May 1<sup>st</sup> 2018

– RESPONSES –

RE: CAO17- 014 (5236 W Mercer Way Critical Area Determination Letter dated February 5<sup>th</sup> 2018)

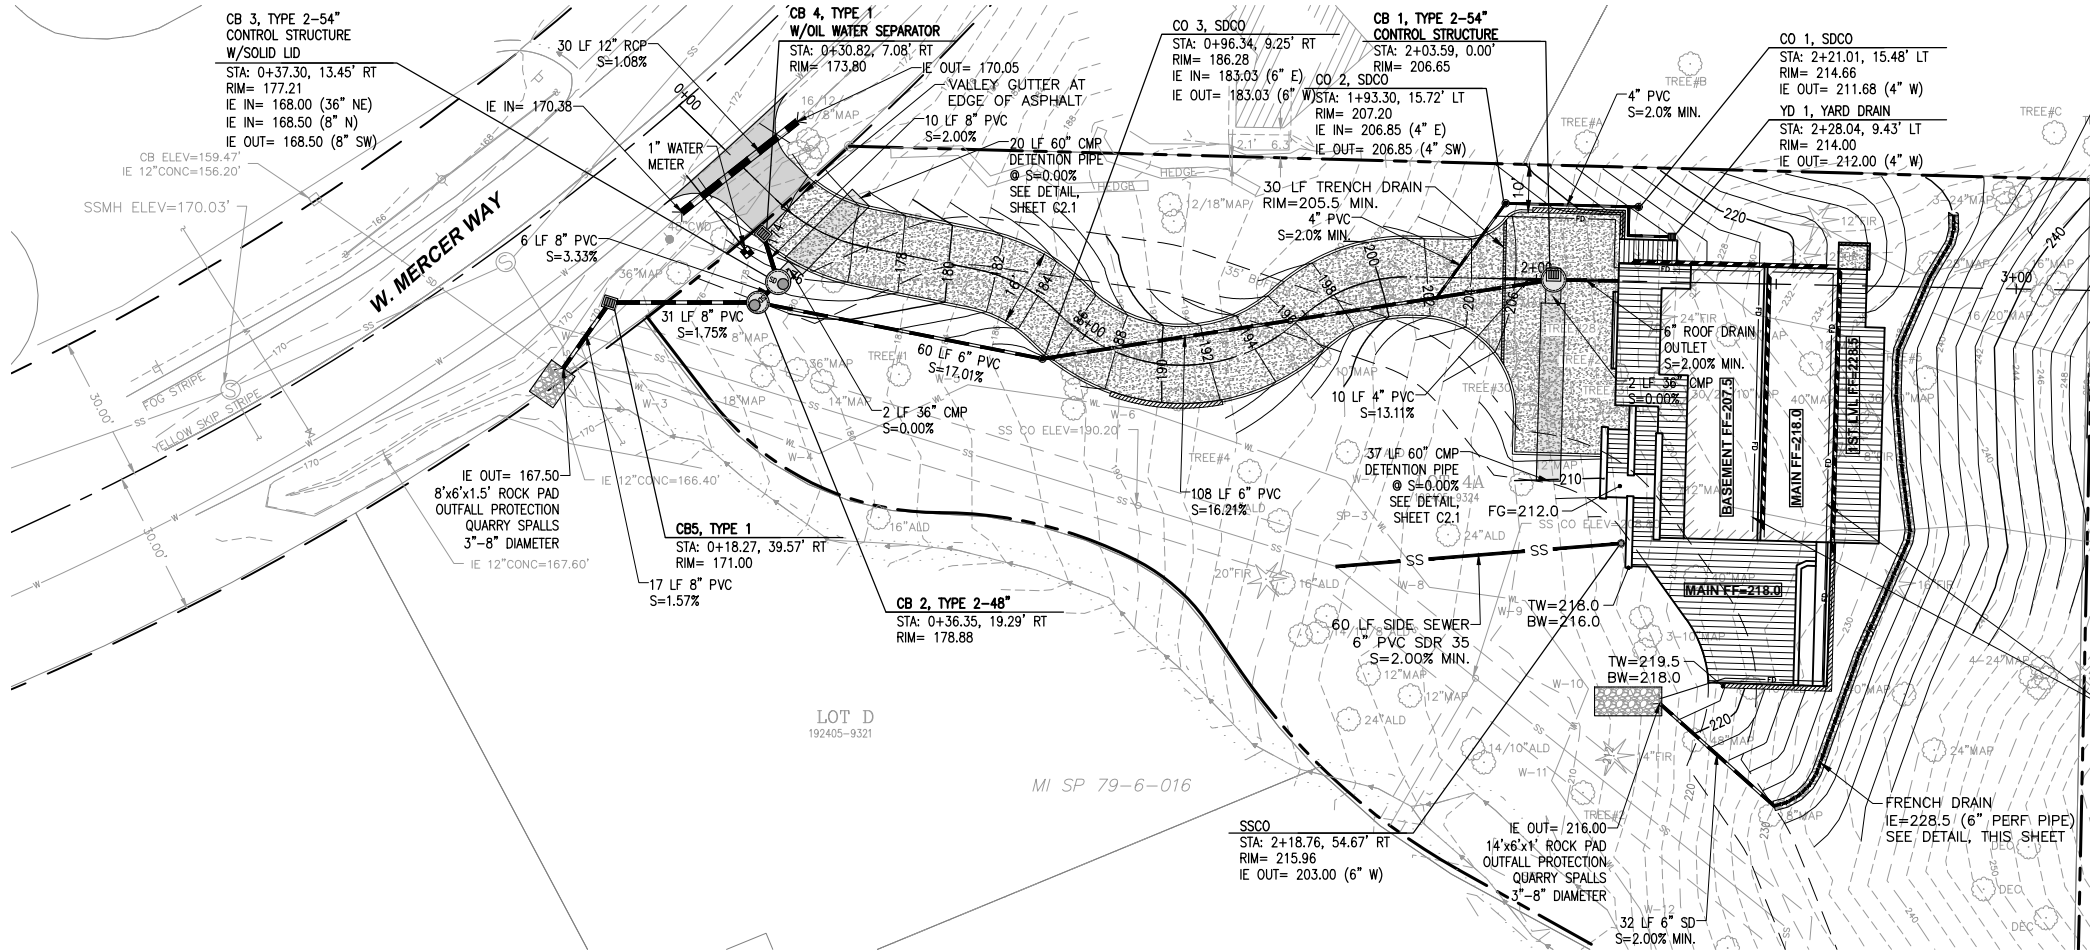
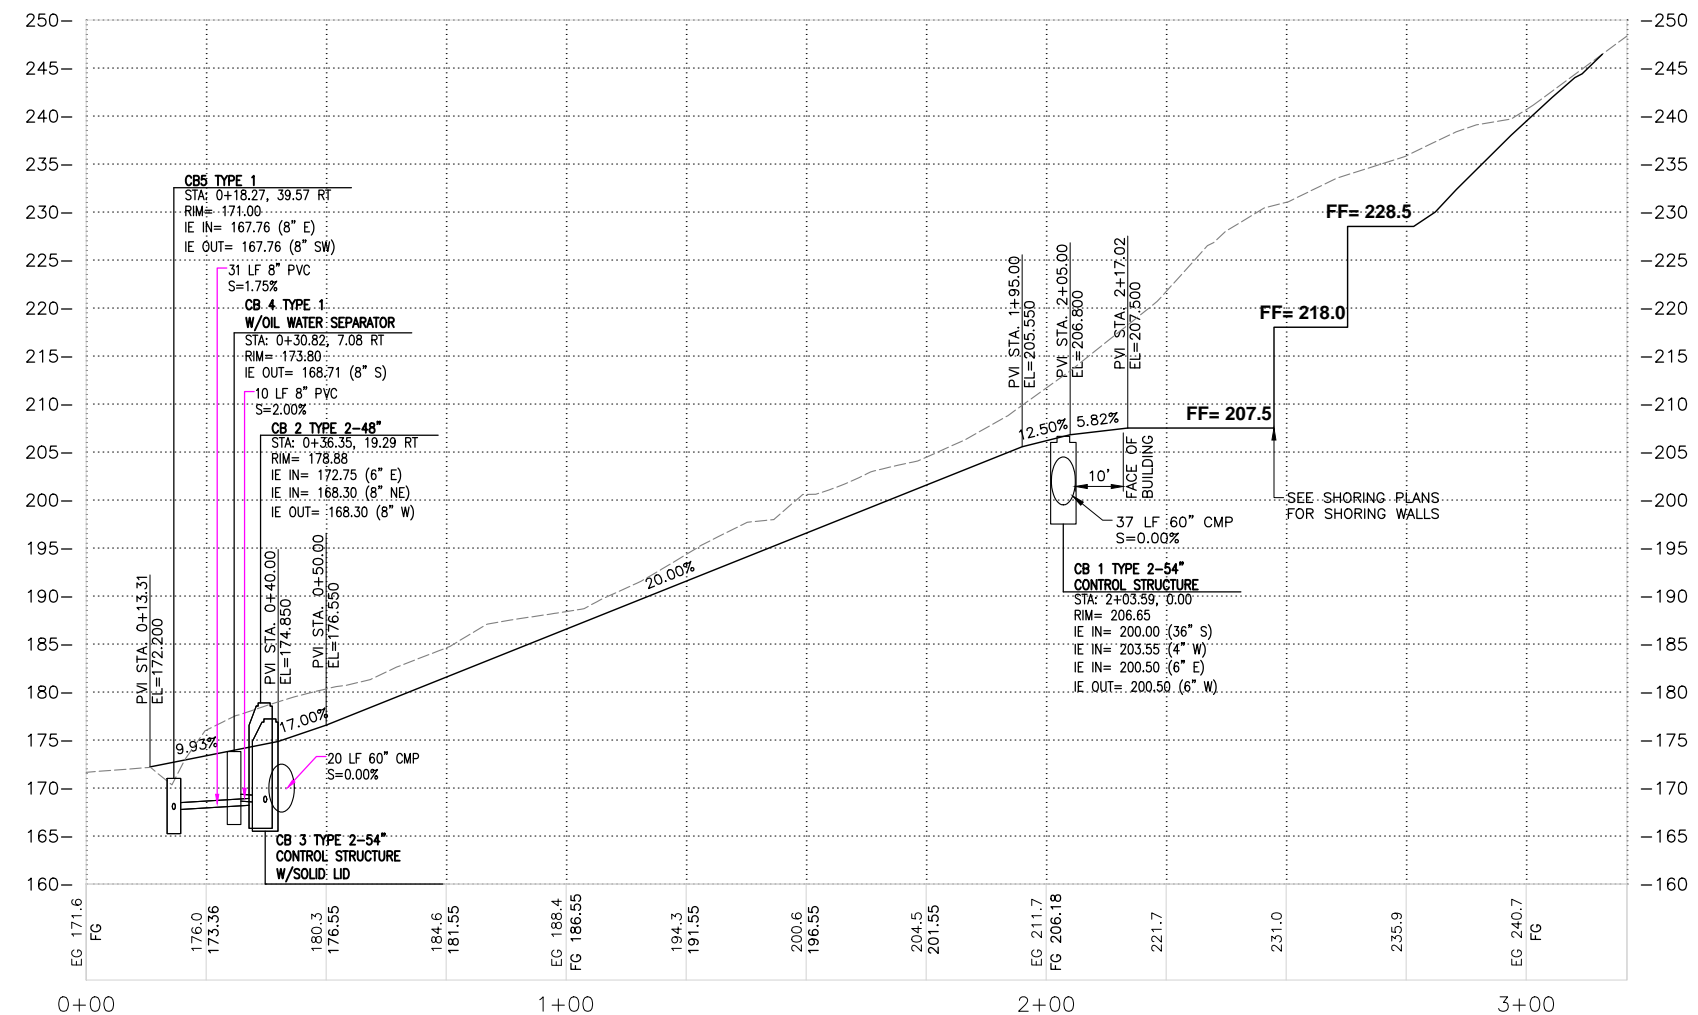
17.Revise plans to install the side sewer connection to the city sewer main on W Mercer Way, avoiding impacts to the wetland.

18.Revise plans to connect footing drains into the proposed drainage conveyance system, rather than using the dispersion pad in the wetland buffer, avoiding buffer impacts.

19.Relocate the drainage system related to the driveway detention system to be further north, avoiding impacts to the wetland.

20.Move the water meter to the north side of the proposed driveway.

21a. The discharge from the detention system should be located to the drainage system north of the driveway. If there is no defined drainage ditch as from the discharge point to City CB27-41, then you will need to provide the piping system from south of the driveway to CB27-41.

**Response: Sewer alignment revised per City comment direction. See sheet civil plans, sheet C2.0.**

**Response: Dispersion pad is recommended to maintain existing hydrology patterns as necessary for wetland hydration. The dispersion pad allows upstream tributary surface drainage and interflows to be collected via wall drains and routed to the dispersion pad, mimicking the predeveloped hydrology. See sheet civil plans, sheet C2.0.**

**Response: Storm detention utility relocated as directed. No temporary construction or permanent impacts proposed to the wetland. Construction temporary shoring added to eliminate need for cut slope impacts to the wetland and buffers and minimize disturbance within the wetland buffer. See sheet C2.0.**

**Response: Water meter relocated to north side of driveway as directed. See sheet C2.0.**

**Response: PACE professional opinion is to route all surface water to the south of the driveway to the subject property’s natural discharge location per the 2014 DOE SWMMWW Minimum Requirement #4 – Preservation of Natural Drainage System and Outfalls. Evaluation of site survey topography concludes that the subject property tributary to the downstream conveyance flow path located south of the proposed driveway (i.e tributary to CB 27-42A, not CB 27-41). Furthermore, topographic survey information concludes that there is a vertical crest curve in the W Mercer Way north of the proposed driveway. Proposed stormwater outfall is located outside of the wetland area and there are no adverse impacts to the wetland are anticipated. See civil plans, sheet C2.0.**

Proposed Residence 5236 West Mercer Way Mercer Island, WA	GENERALIZED SUBSURFACE PROFILE SECTION A - A'	
		Project No. 17-143	Figure No. 3

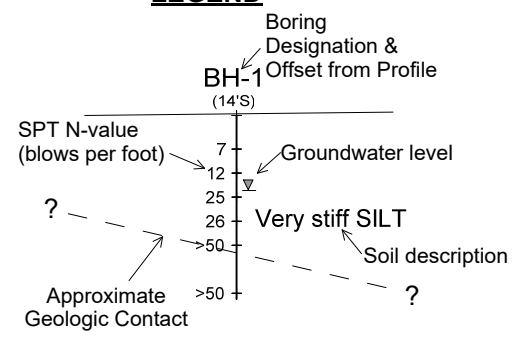
24. In the geotechnical report on Figure 3, the Generalized Subsurface Profile A-A' indicates near the property line to the east of the proposed structure, the absence of alluvium or colluvium within the proposed permanent cut of 2 Horizontal to 1 Vertical (2H:1V). It suggests that the cut would be within the underlying glacial till. We agree that if that is the case, the proposed cut would be stable, however there is no subsurface information to support that interpretation of the slope conditions. Additional subsurface information should be provided to support the current interpretation of conditions on the slope east of the proposed structure location.

25. If the cut will expose alluvium or colluvium (with SPT blowcounts less than 10) and not just glacial till as suggested by Figure 3 in the geotechnical report, stability analyses should be provided to verify that an adequate factor of safety against slope instability will be present with the proposed permanent cut. These analyses should consider potential perched water conditions on top of the glacial till. These analyses should also include the slope above and east of the property.

**Response: Geotechnical Engineer provided a letter addressing issue. This letter is upload to the permit intake site.**

SCALE:	DATE:
AS SHOWN	10/10/17
DESIGNED BY:	CHECKED BY:
DW	JS
JOB NUMBER	17387
SHEET:	<b>C1.0</b>
SHEET <b>4</b> OF <b>10</b>

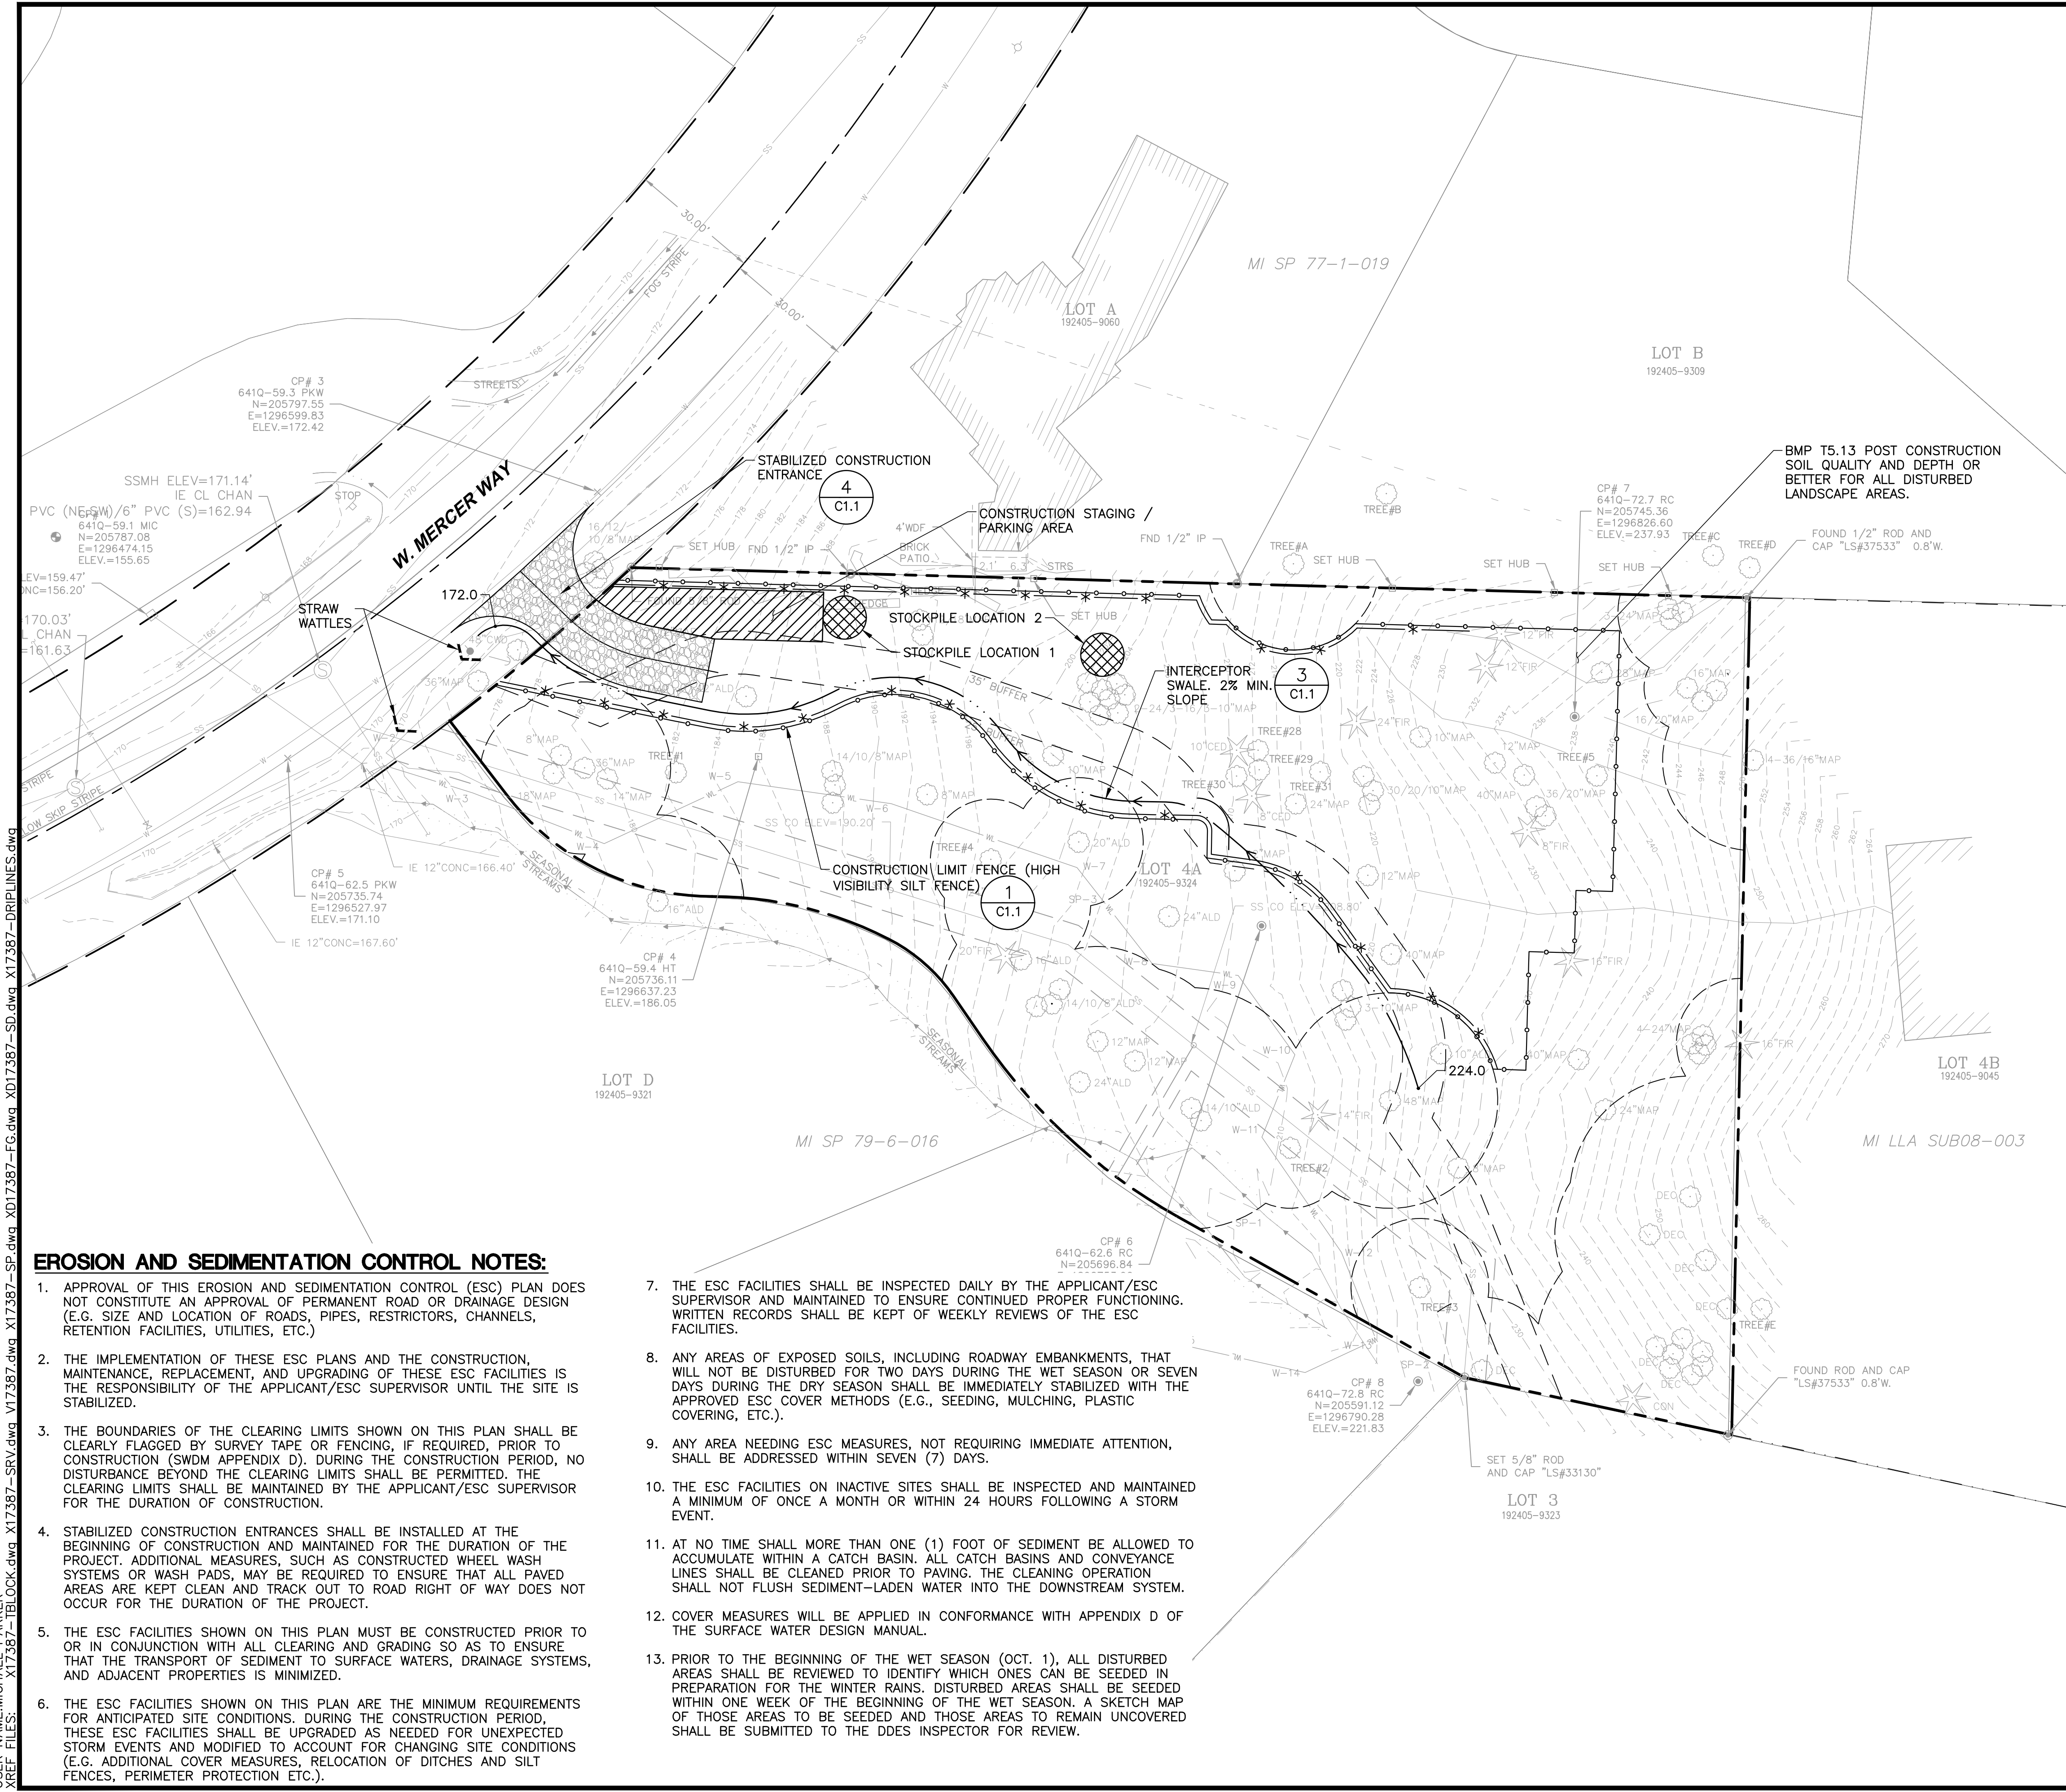
6. Please provide a draft construction management plan, describing anticipated construction sequencing, stock pile locations, and construction worker parking.

**Response: Stock pile location and construction staging/parking area identified. Project specific construction sequence plan provided and described. See civil plans, TESC plan - sheet C1.0.**
